Memorandum

To: Rick Goduti
From: Mike Nugent/Manager of Inspection Services
Date: 09/24/2003
Re: Oceans East 739 Ocean Ave. (423 A004)

Partial Review Comments;

**A7.4**

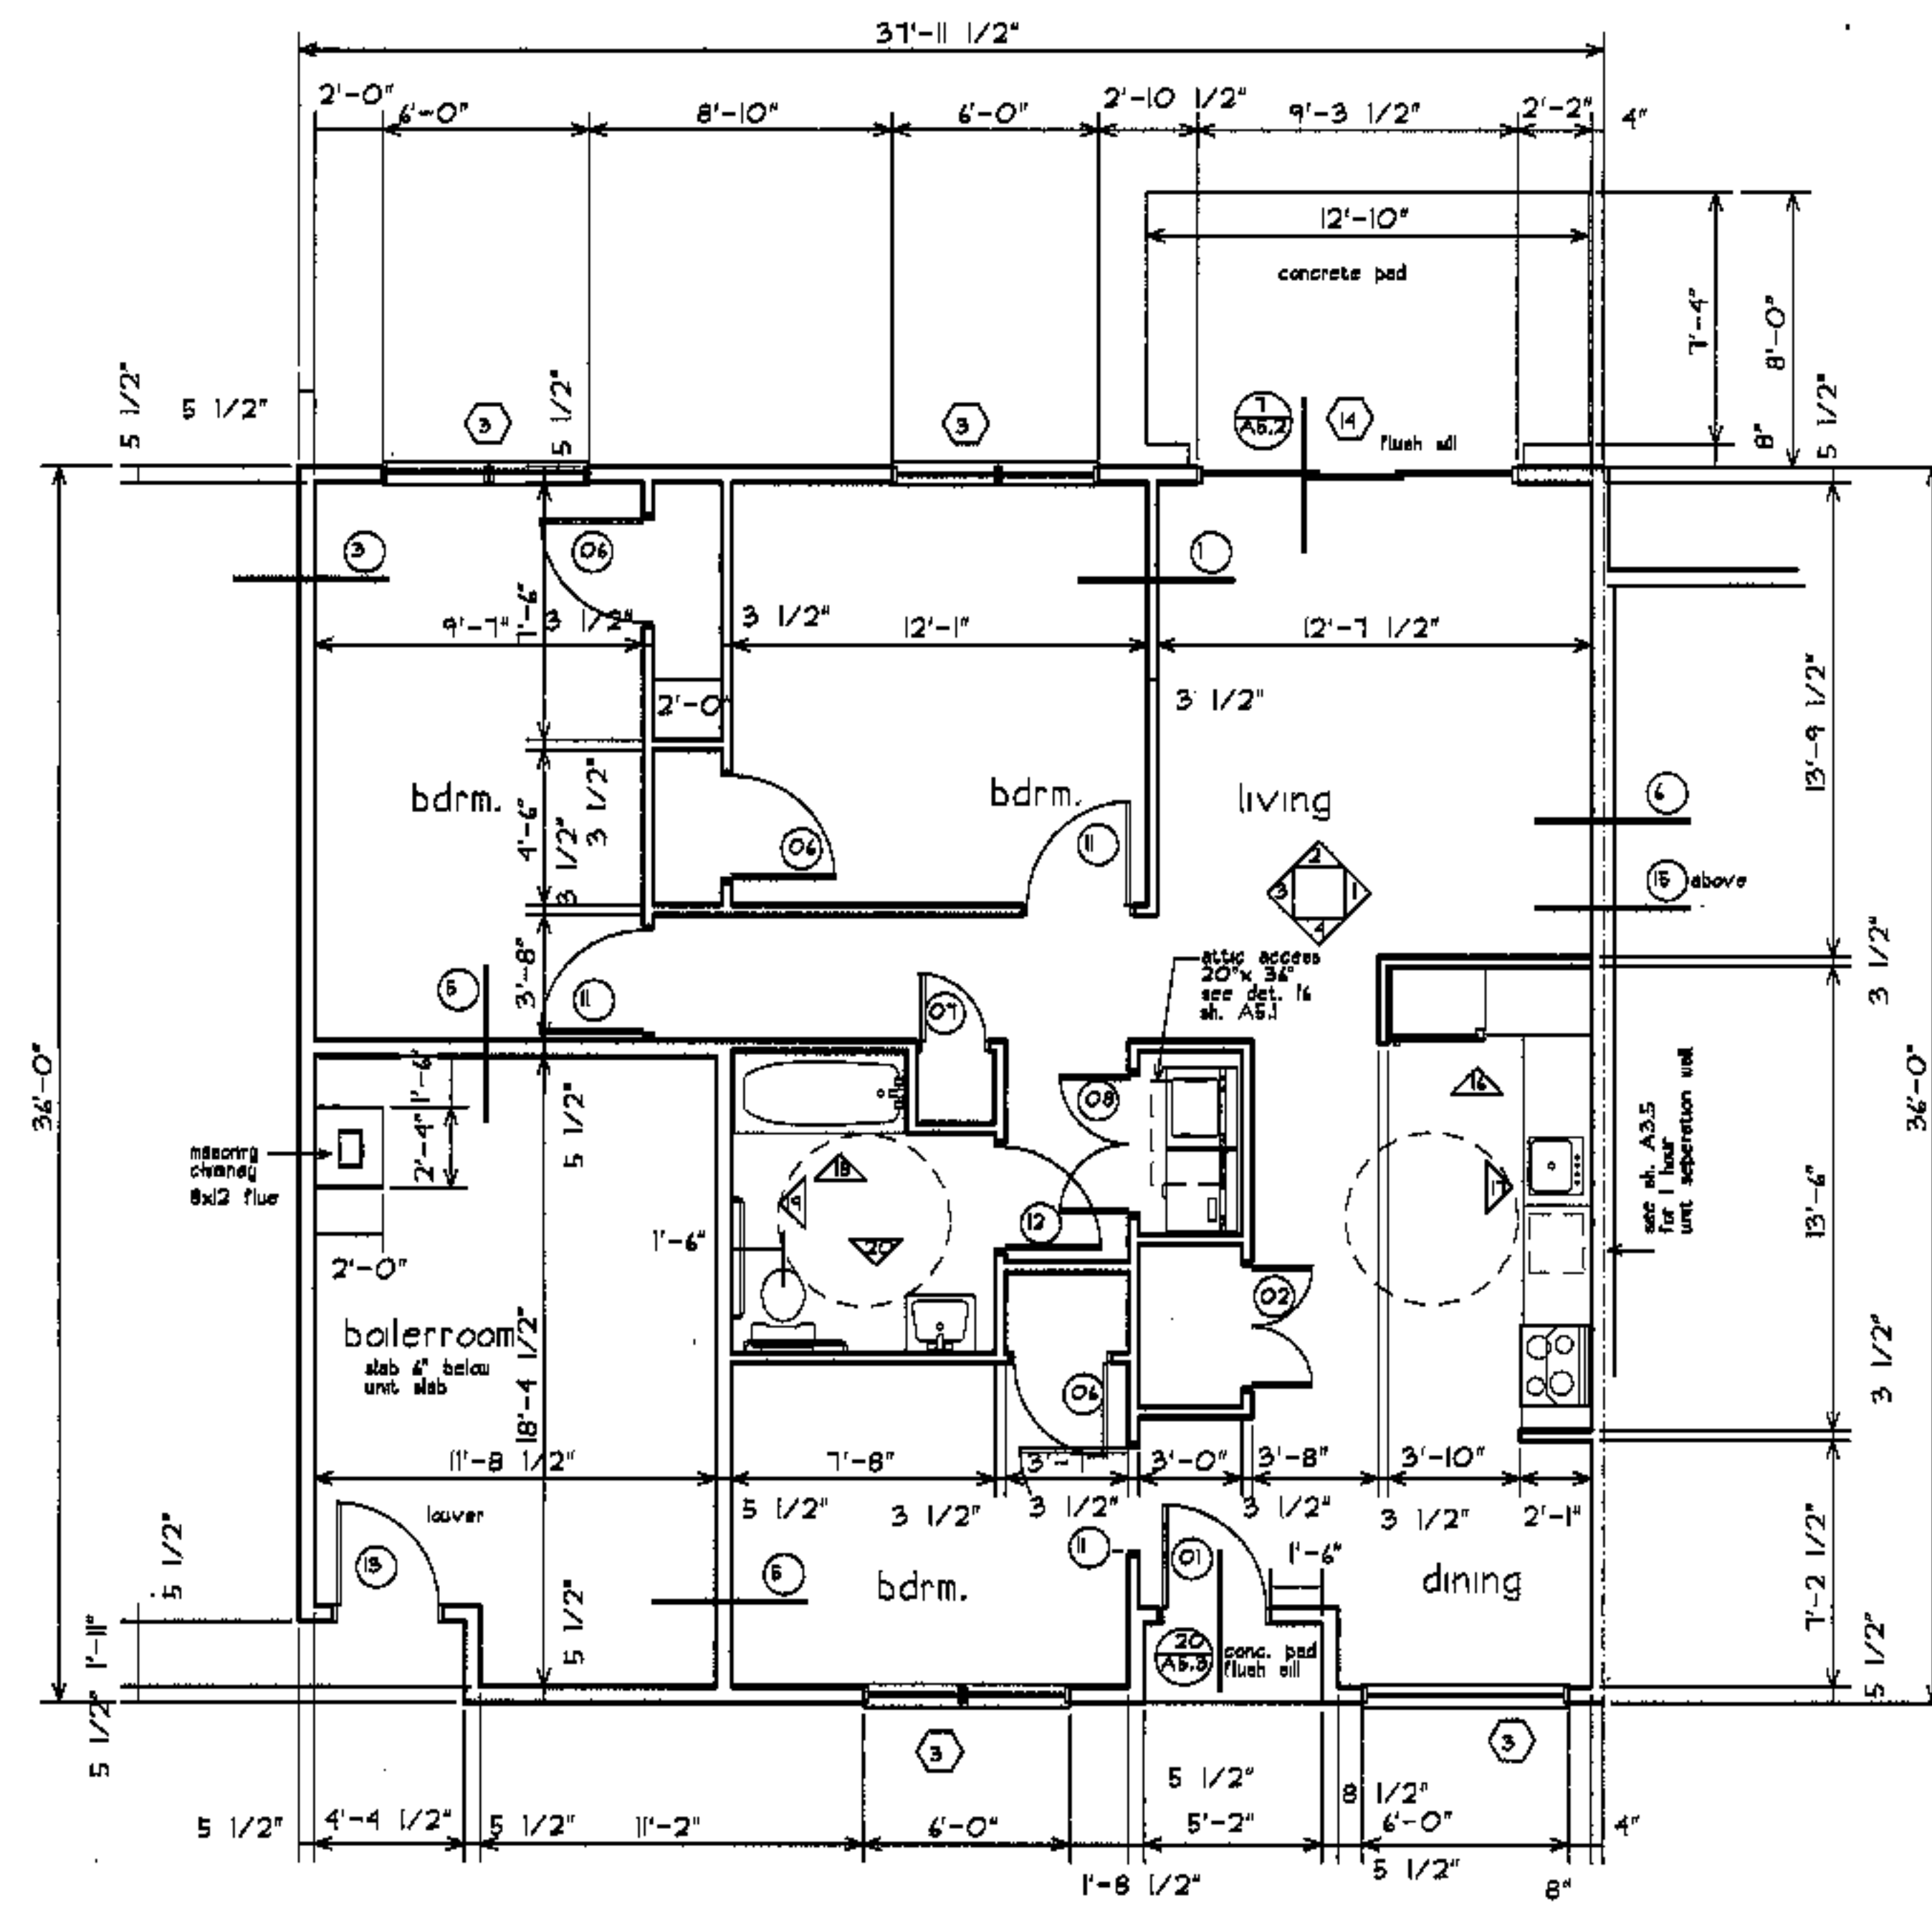
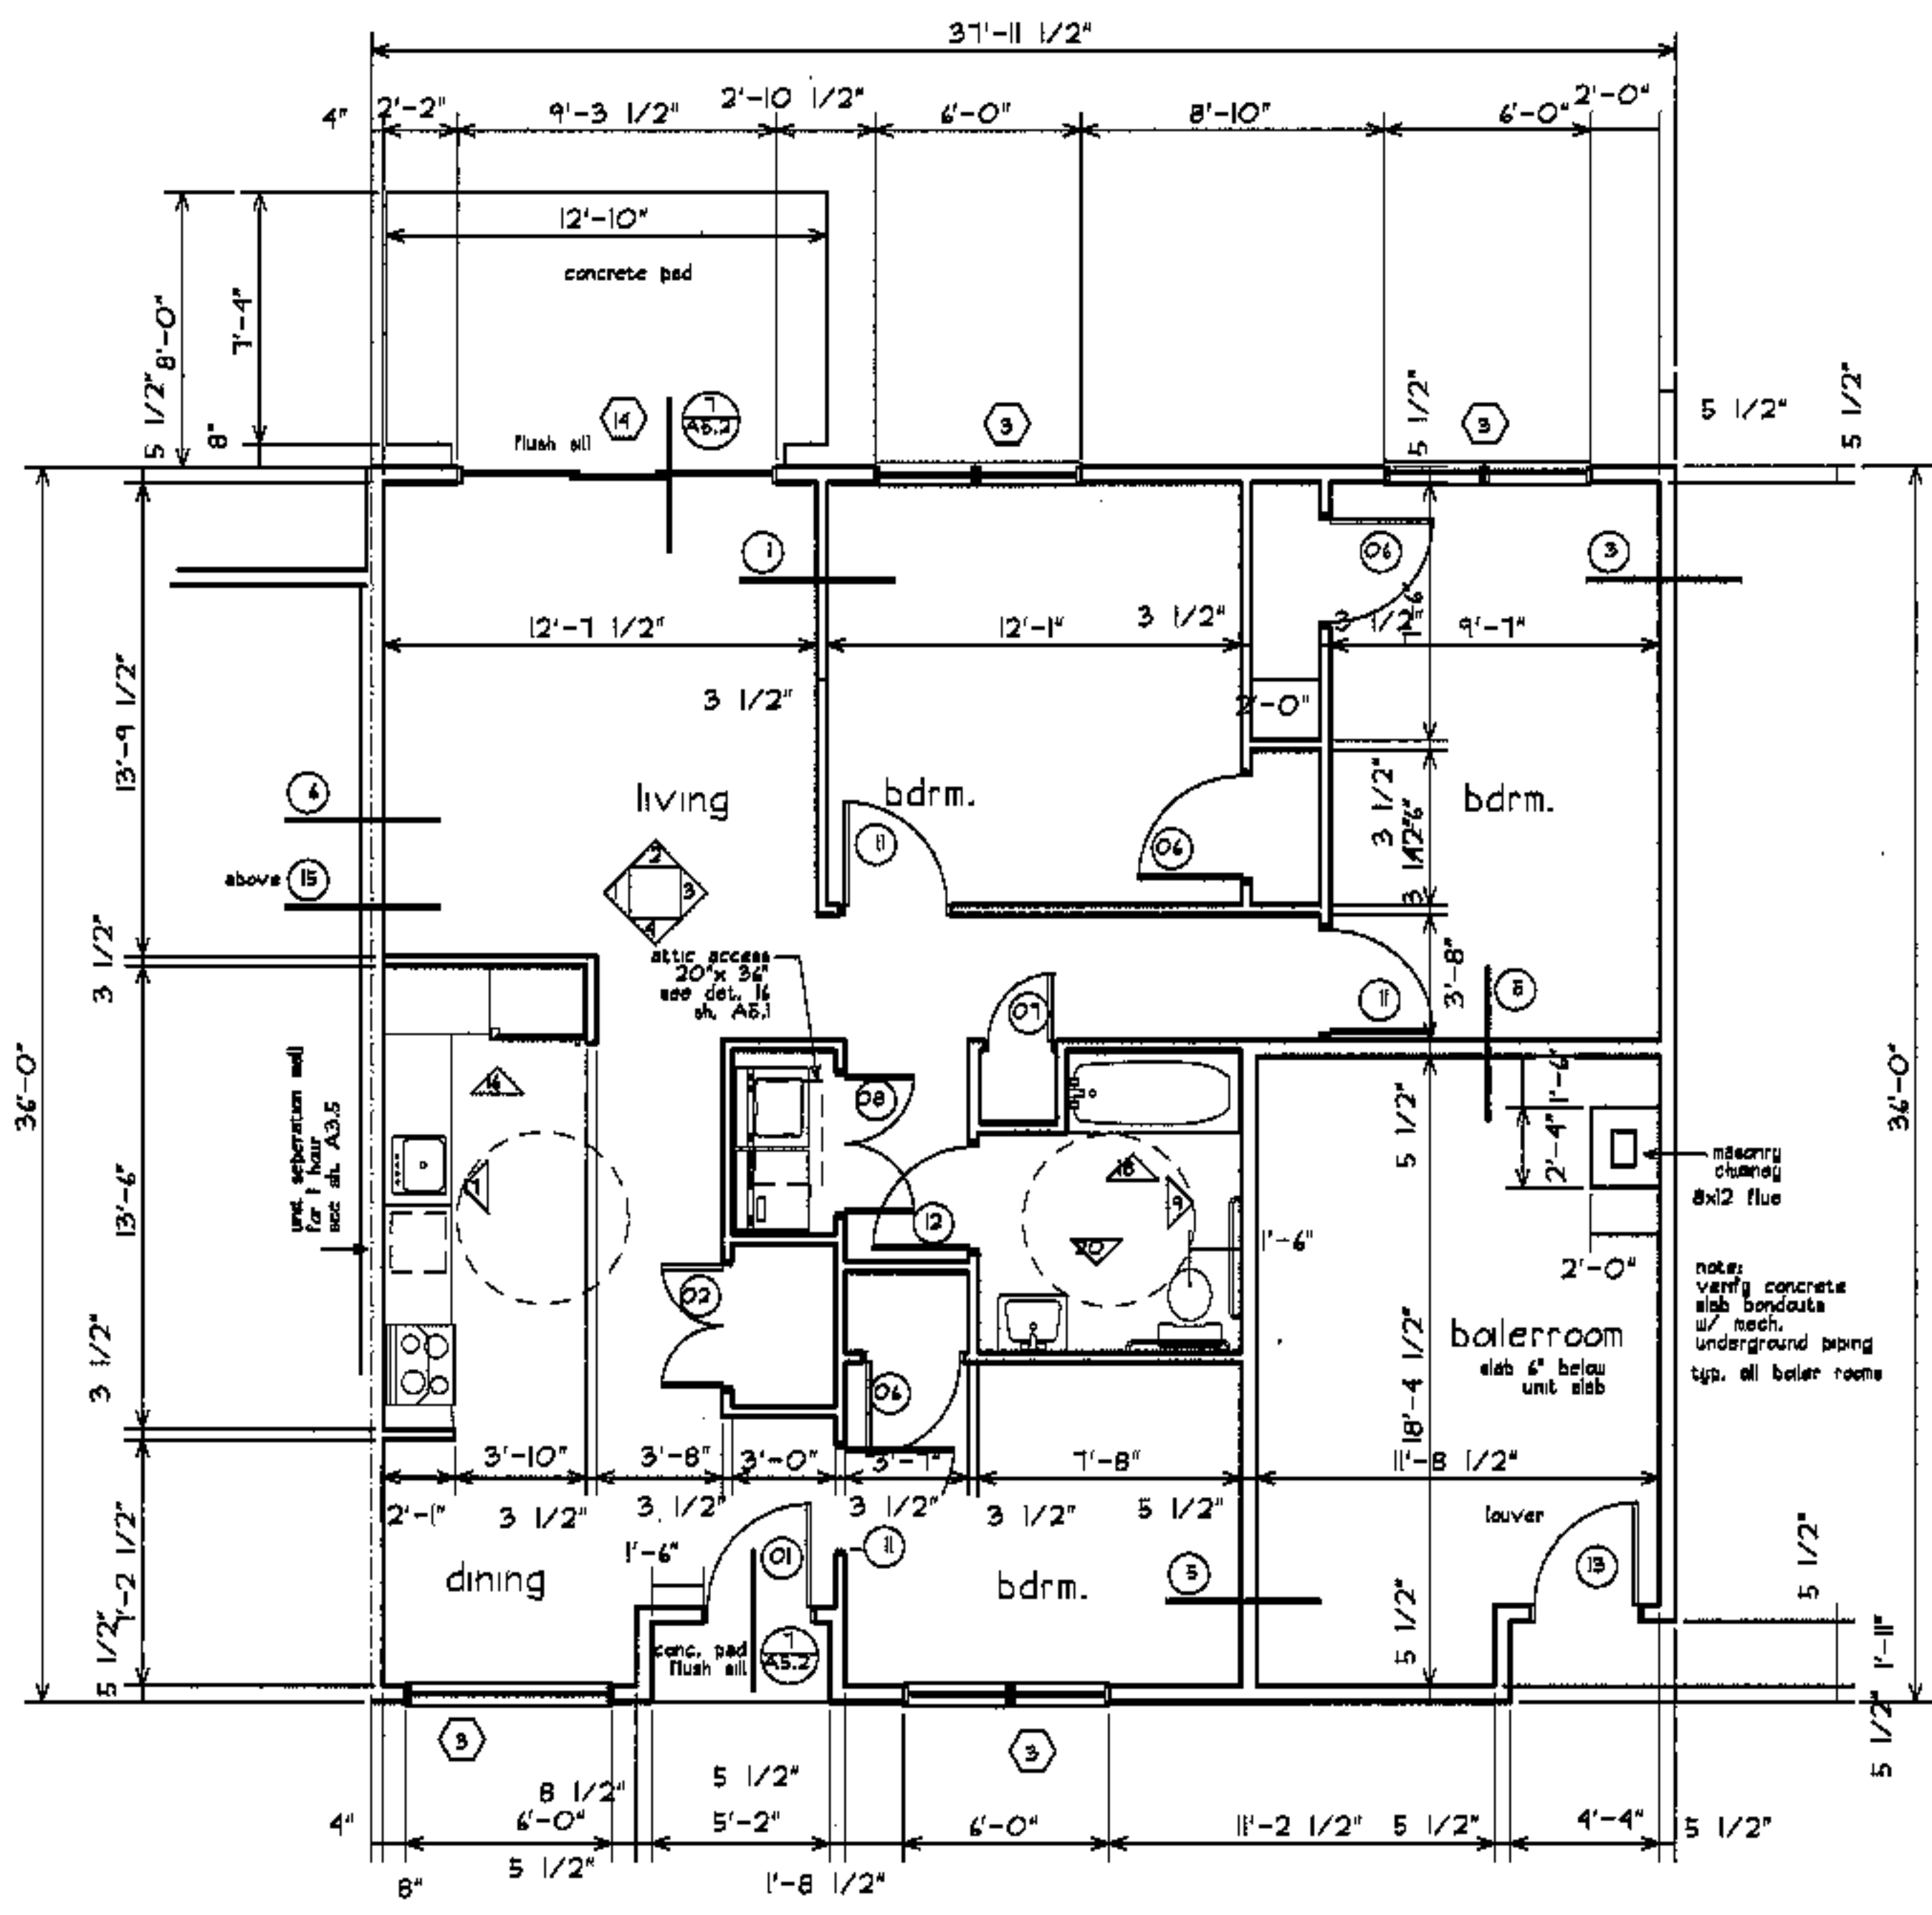
- 5) A3.1 and F5.1 Footing dimensions, anchor bolt spacing from corners, type of vapor barrier. what is "a.i.b." in the wall section?
- 6) A3.2 What brand and type of floor and roof trusses specifically

**F1.2**

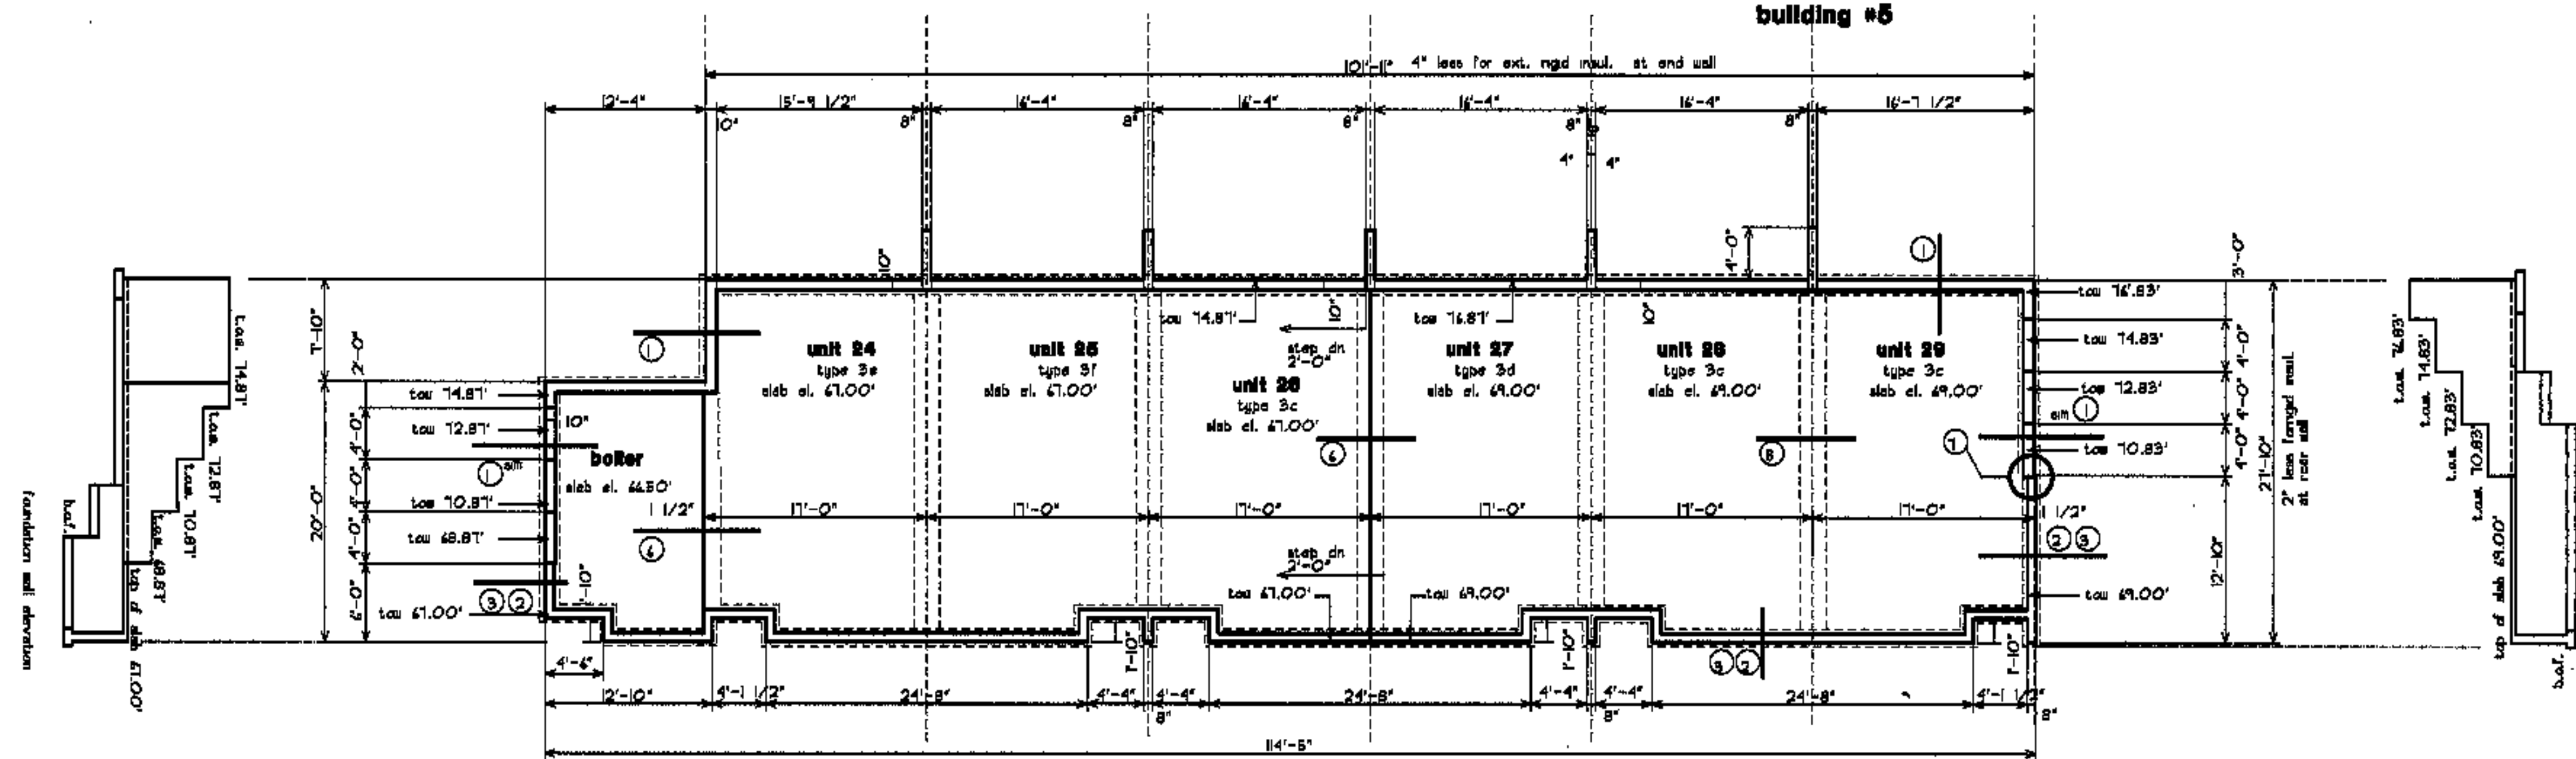
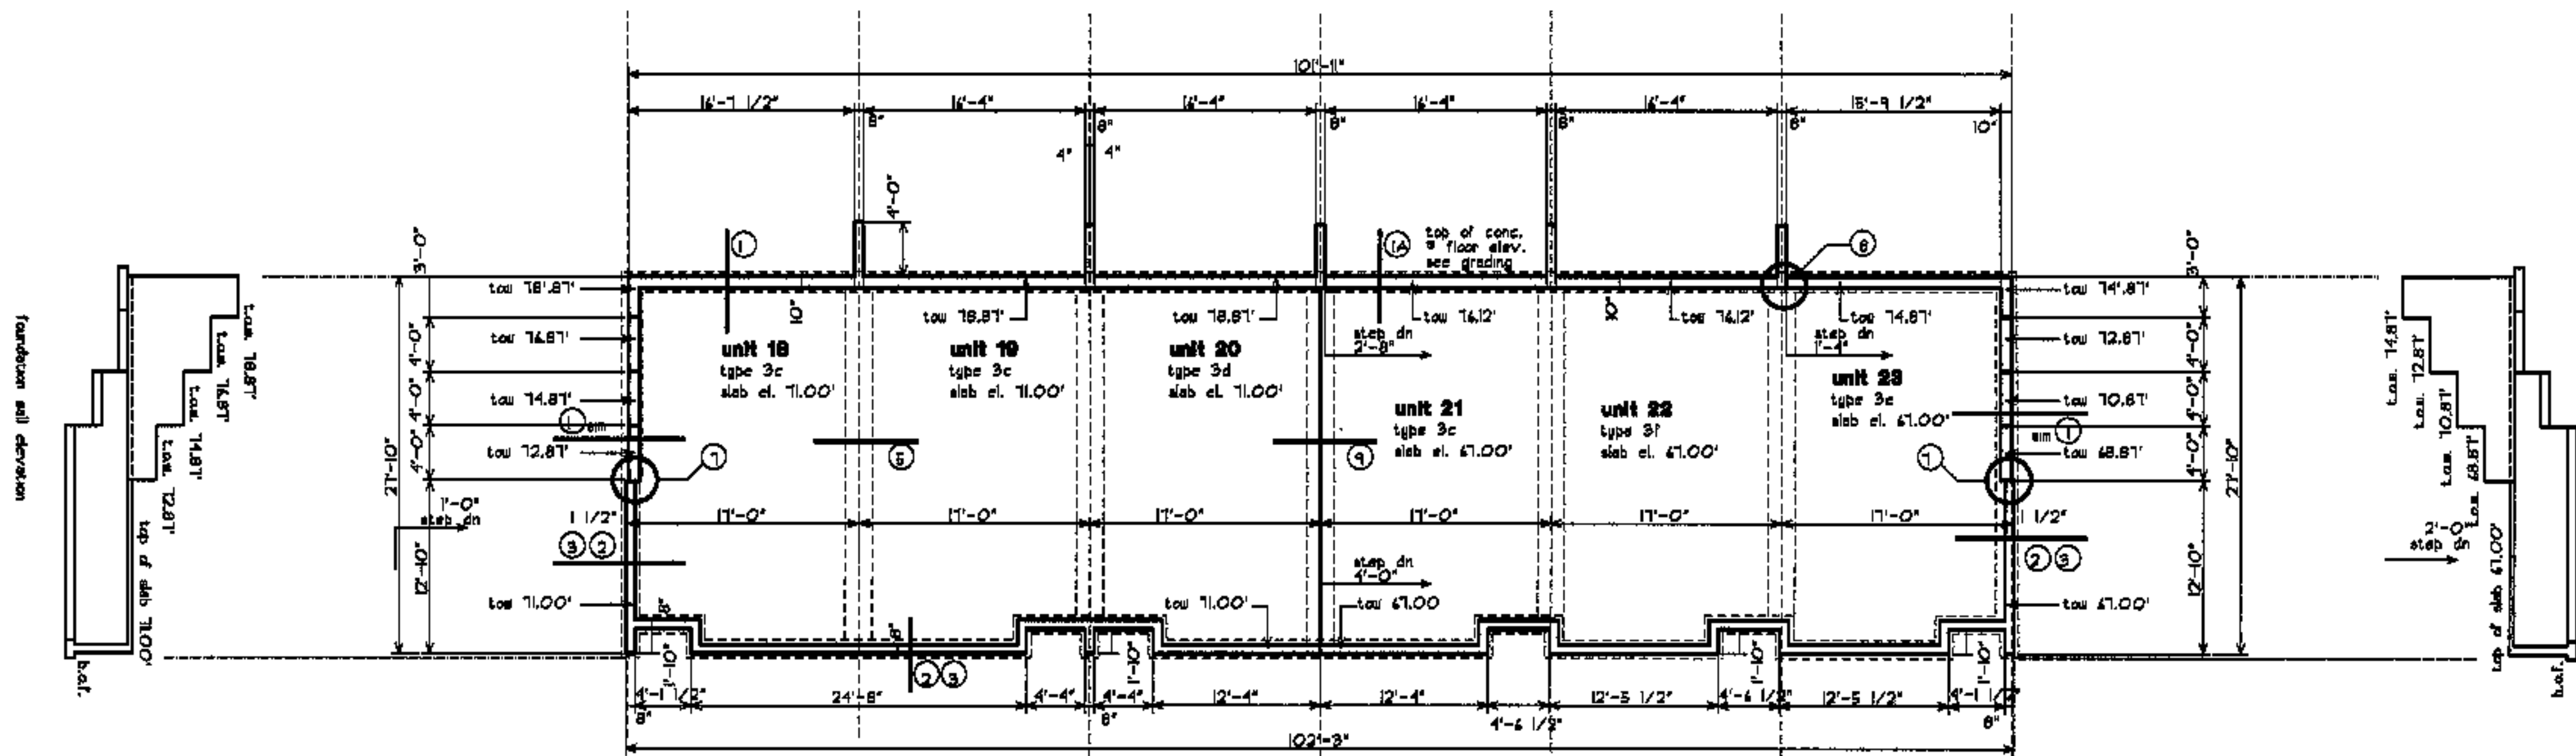
- 15) What type of Fire Suppression is proposed?
- 16) Stair nosings must be at least $\frac{3}{4}$ of an inch , (1/2 inch shown)
- 17) What is the fire separation assembly in the basements between units that are unlabeled (pages F1.1,2 &3)
